# Rezoning Transportation Analysis

Petition Number: 2020-141

General Location Identifier: Tax ID 12708701

## Revision Log:

**RZ-100**

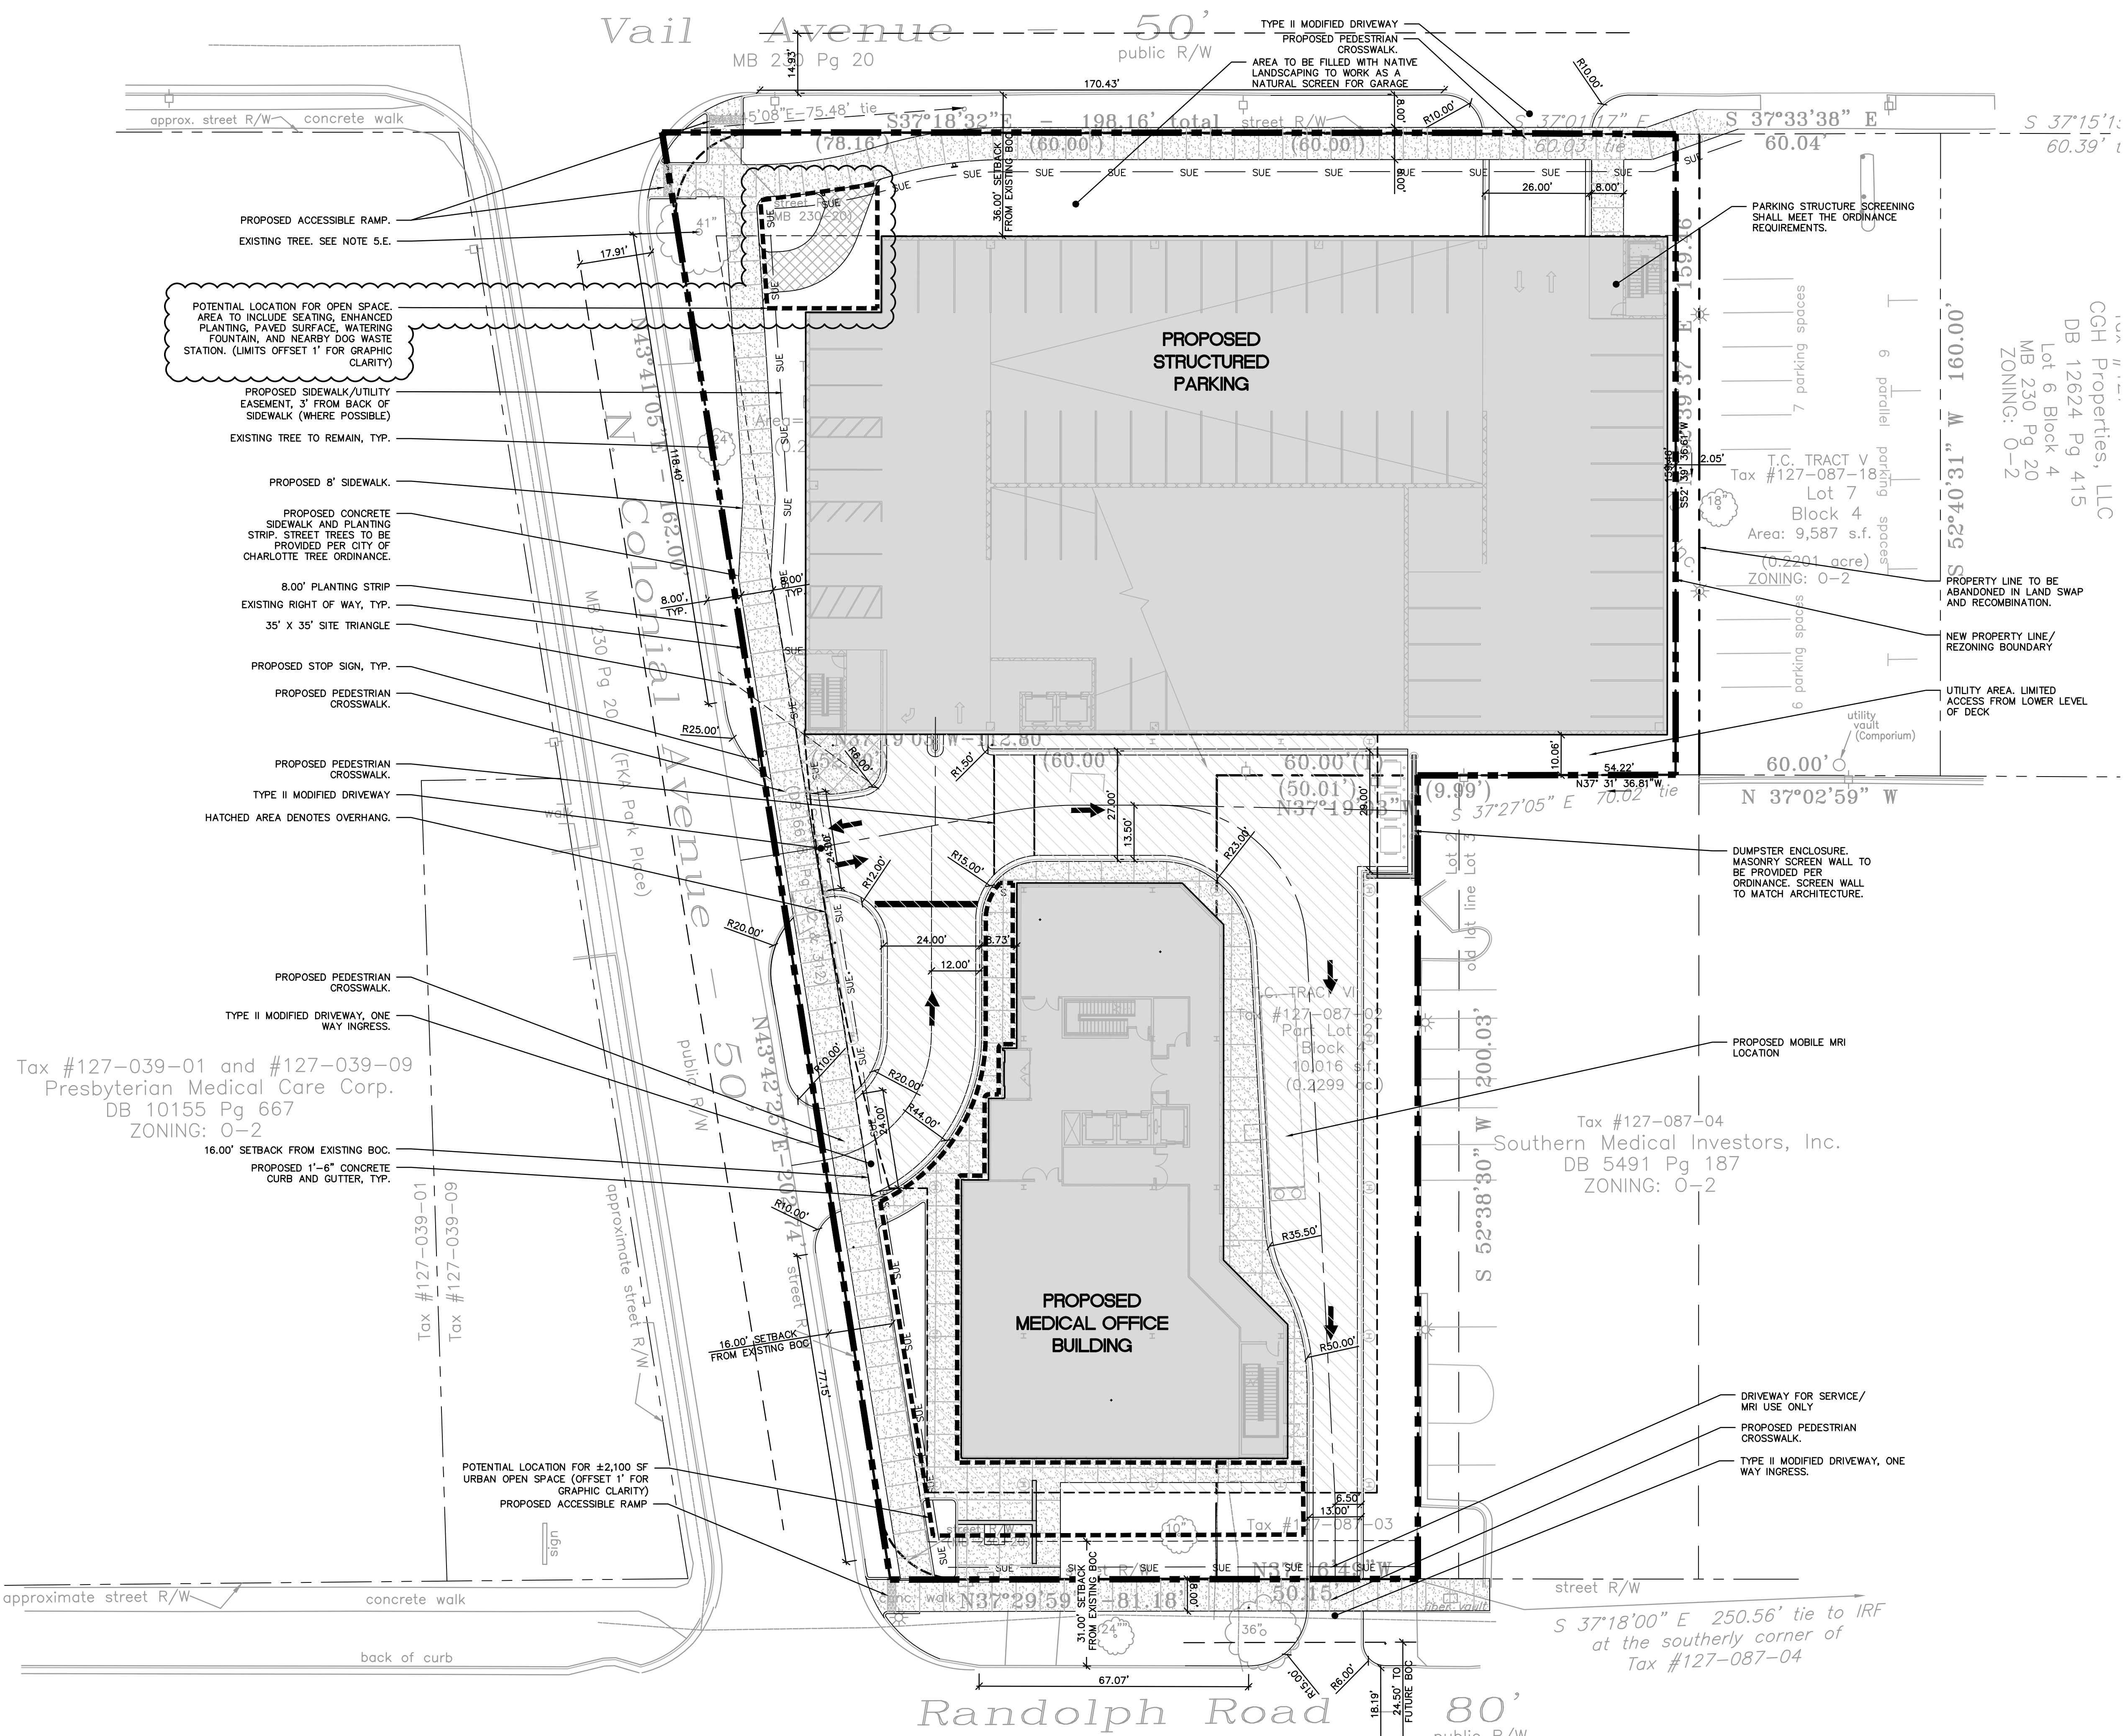
1. ~~**Curblines:** The proposed zoning district has a setback measured from back of the existing or proposed future curblines.~~

Label and dimension curb and gutter from the centerline for each road on the site plan.

5. ~~Revise site plan and conditional note(s) to commit to constructing an 8-foot planting strip, and 8-foot sidewalk along the site's frontage per Chapter 19. The wider sidewalk also meets the Charlotte WALKS Policy.~~

6. ~~Revise site plan and conditional note(s) to commit to constructing two ADA Curb ramps per intersection quadrant in accordance with the ADA law and PROWAG. The site plan shall label and dimension these items from the back of curb and gutter.~~
7. ~~A site plan note specifying that all transportation improvements will be approved and constructed before the site's first building certificate of occupancy is issued is needed. The petitioner may phase transportation improvements if said improvements and phasing are explicitly described in site plan notes.~~
